# A47 Wansford to Sutton Dualling

**Scheme Number: TR010039**

## **9.24 Applicant's Response to the Examining Authority's Further Written Questions (ExQ2)**

April 2022

Development Consent Order Drawing Number:  
**TR010039/APP/2.8(l)**

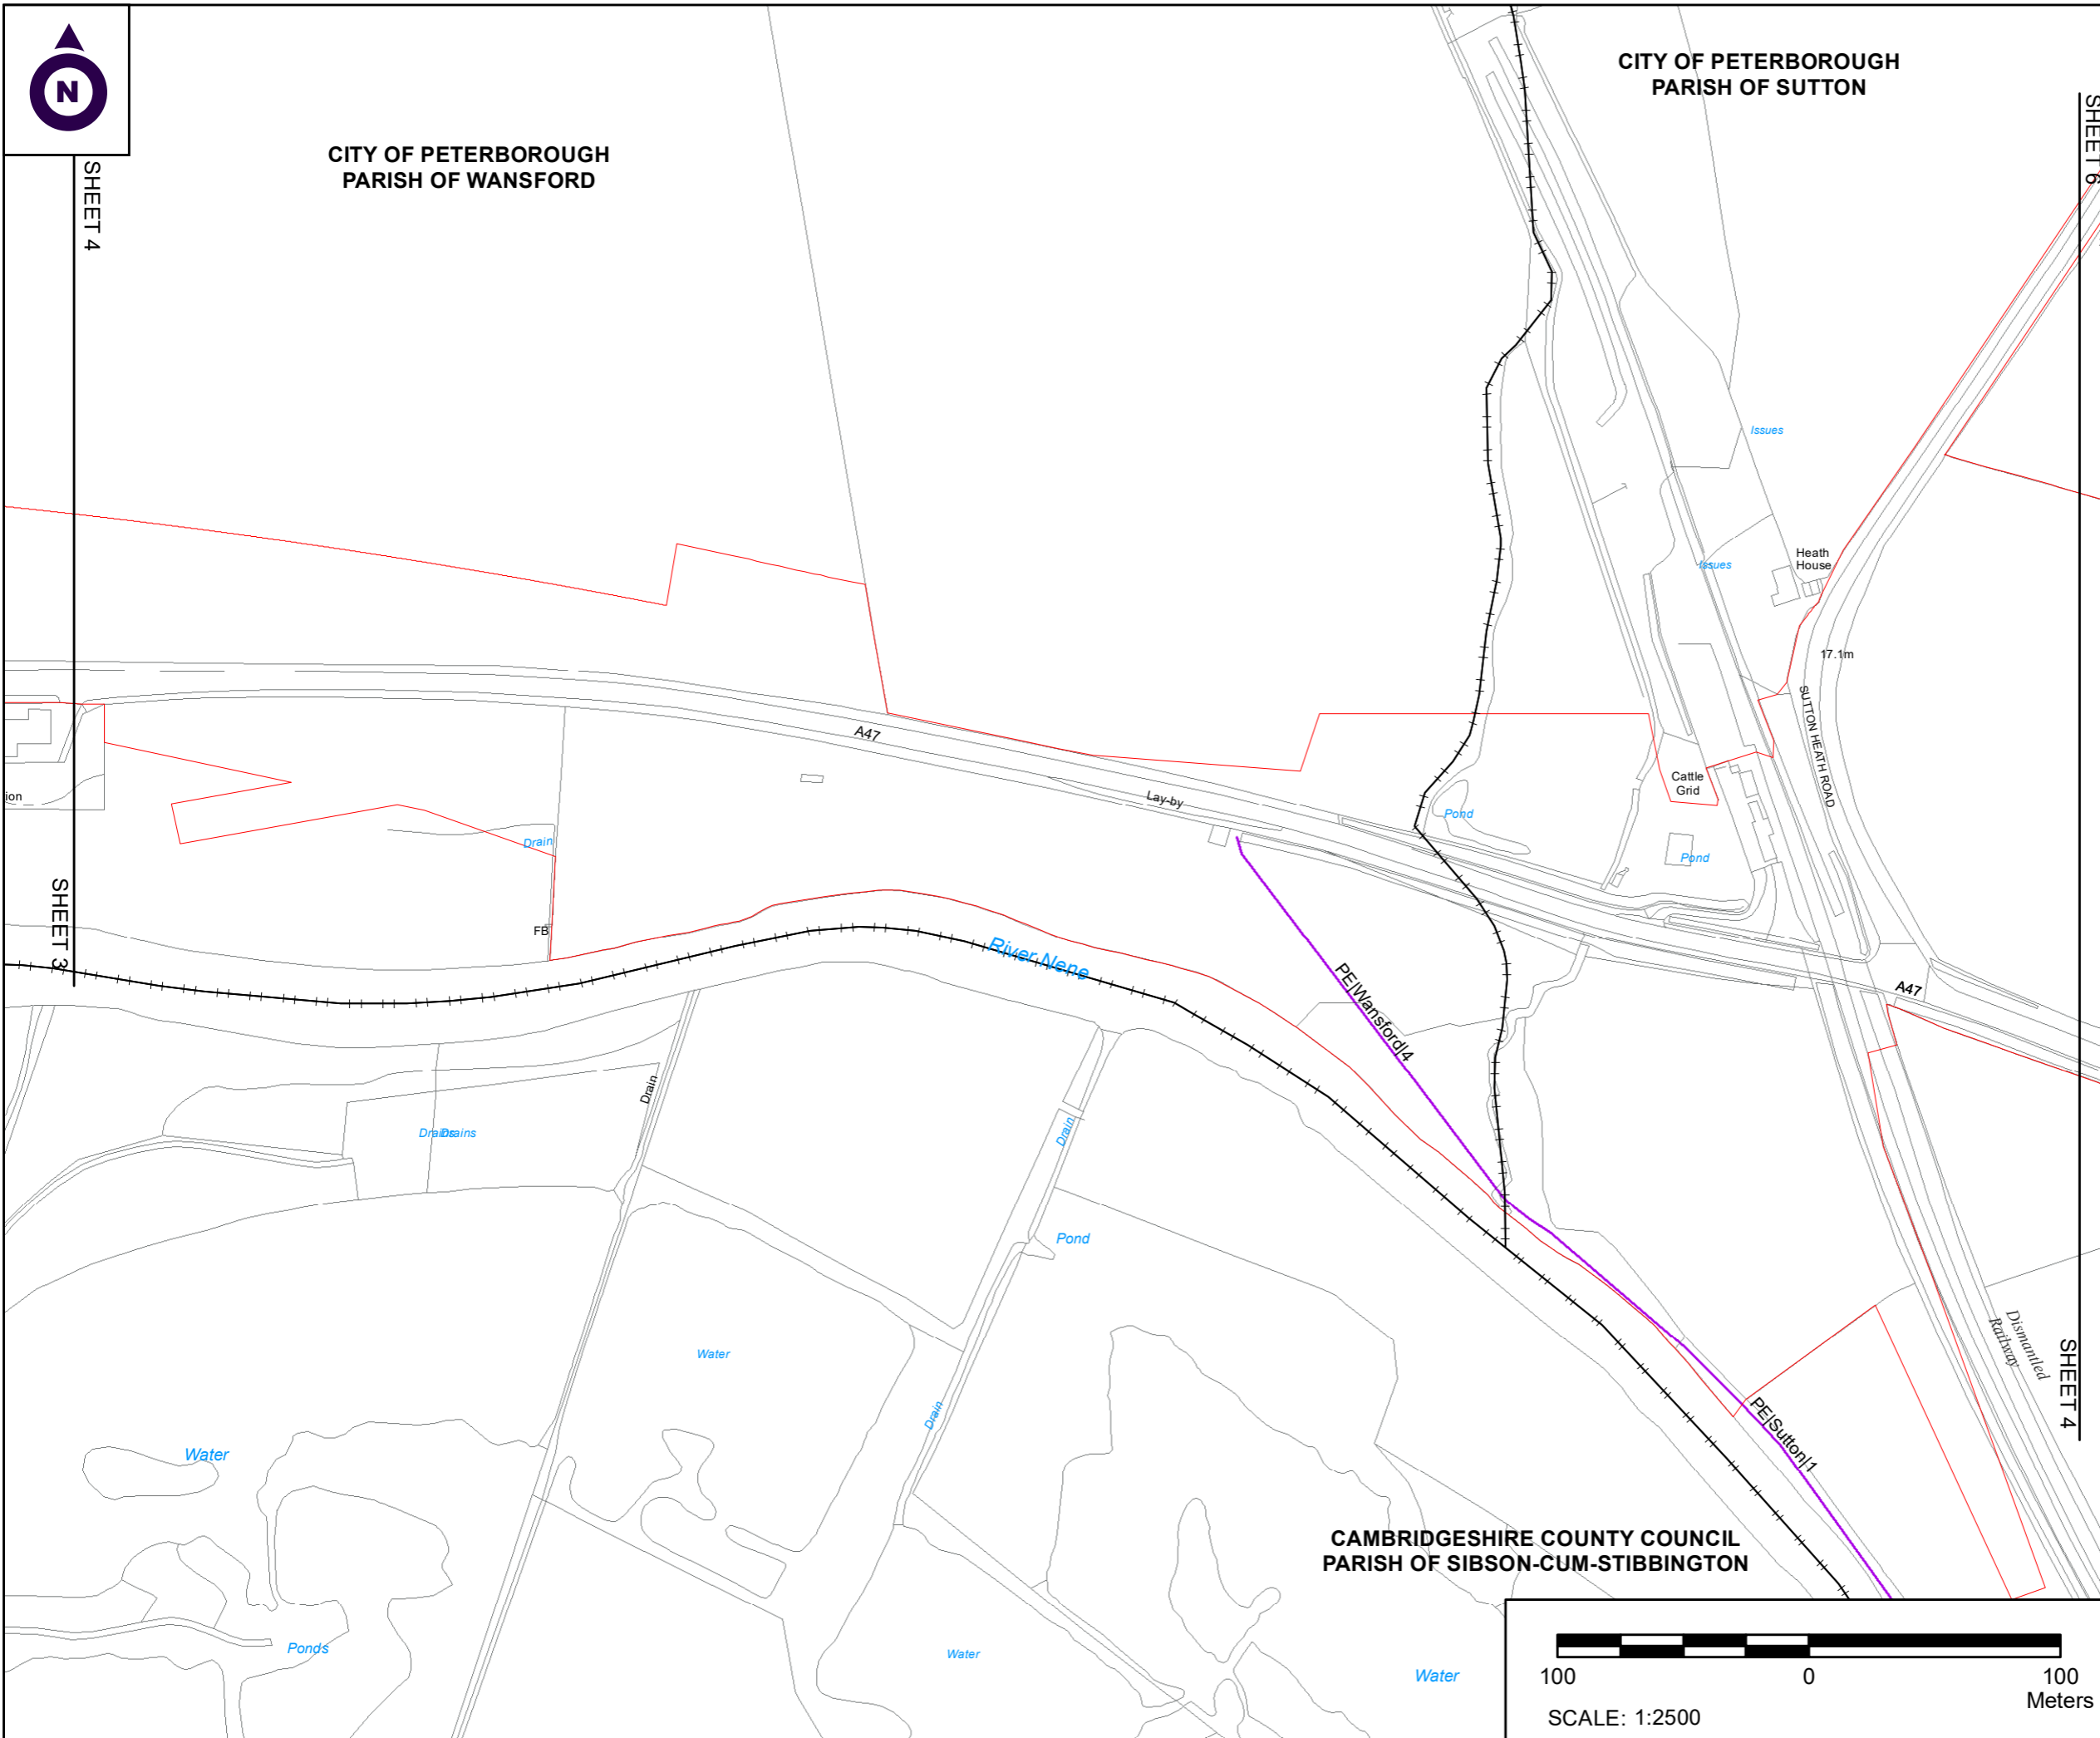
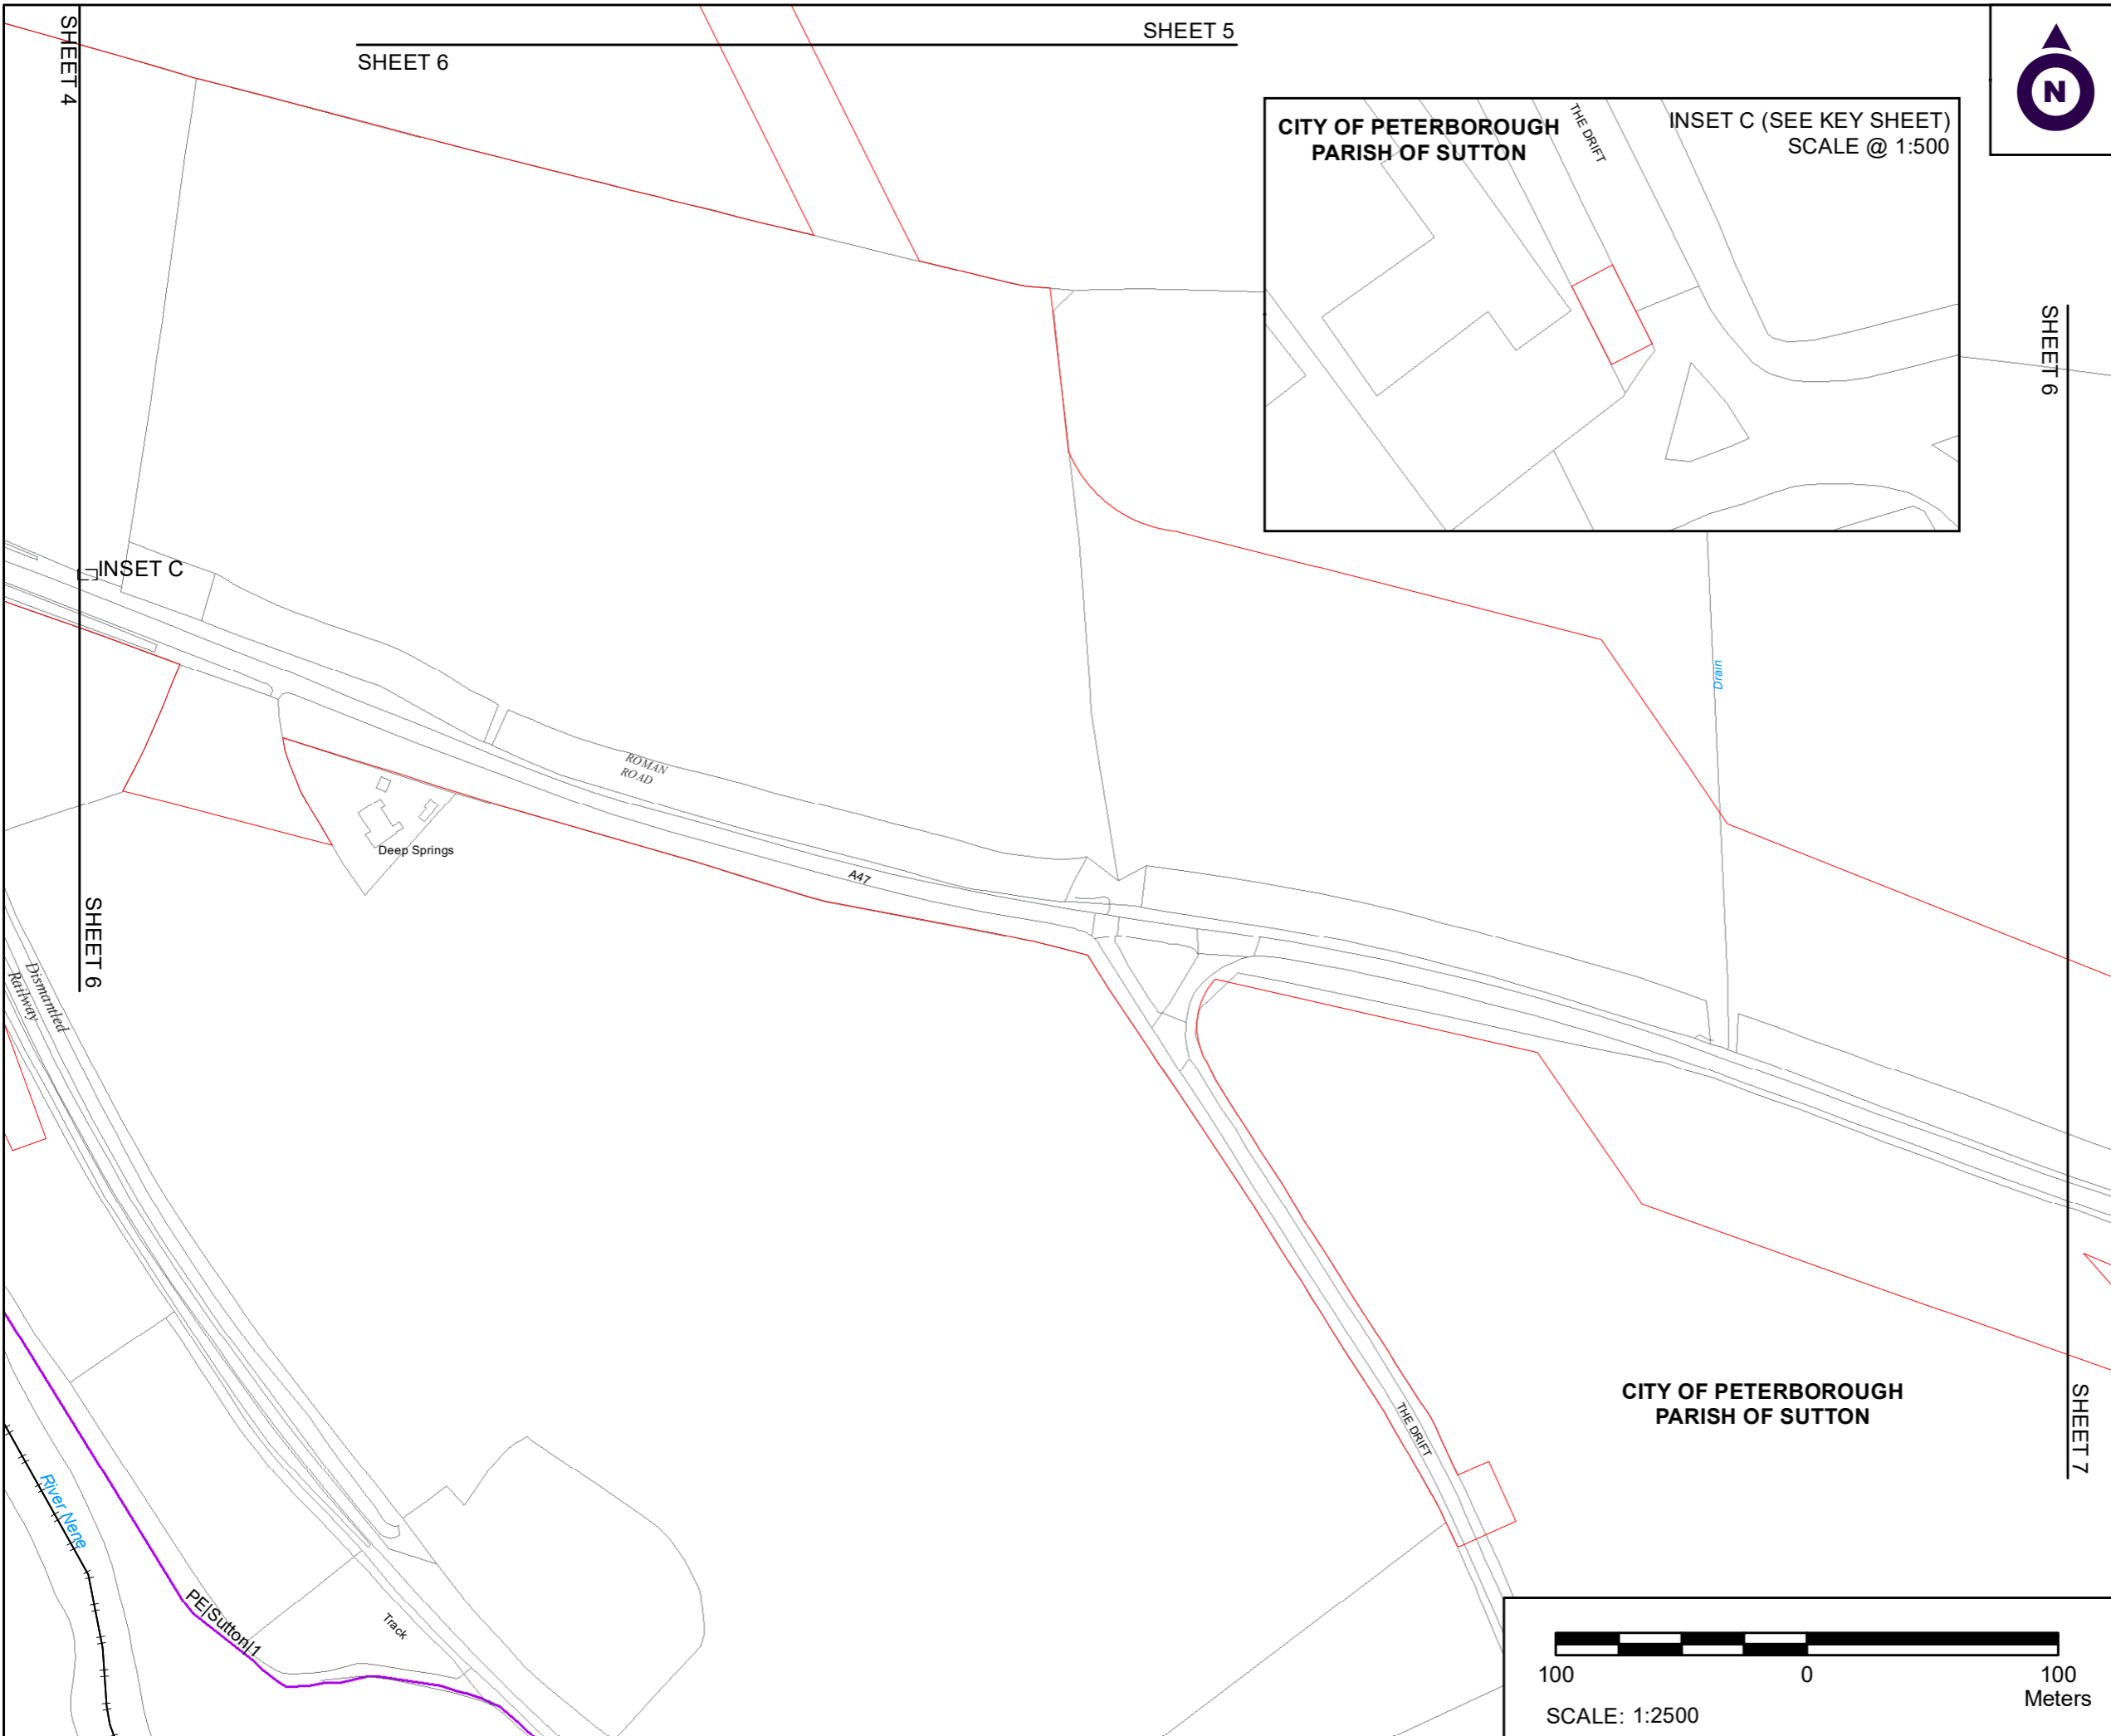
2.3.5.	The Applicant	<p><b>Land Plans</b> [REP2-003] and <b>Crown Land Plans</b> [REP2-007]</p> <p>a) The shape of Inset F showing the area around 6 – 12 (evens) Great North Road is not the same as that on the plans and includes additional land. Can these please be aligned?</p> <p>b) The same applies to Inset A on Sheet 5.</p> <p>c) Could Sheet 3 Inset B on Sheet 2 please be made larger and also the “cut-line” shown on Sheet 3 included.</p> <p>d) Neither Inset A nor Inset C on Sheet 6 appear to have been identified on the main plan. Could this please be included.</p>	<p>The Land Plans (<b>TR010039/APP/2.2 Rev 3</b>) and the Crown Land Plans (<b>TR010039/APP/2.8 Rev 2</b>) have been updated and submitted at Deadline 5 to address these points.</p>
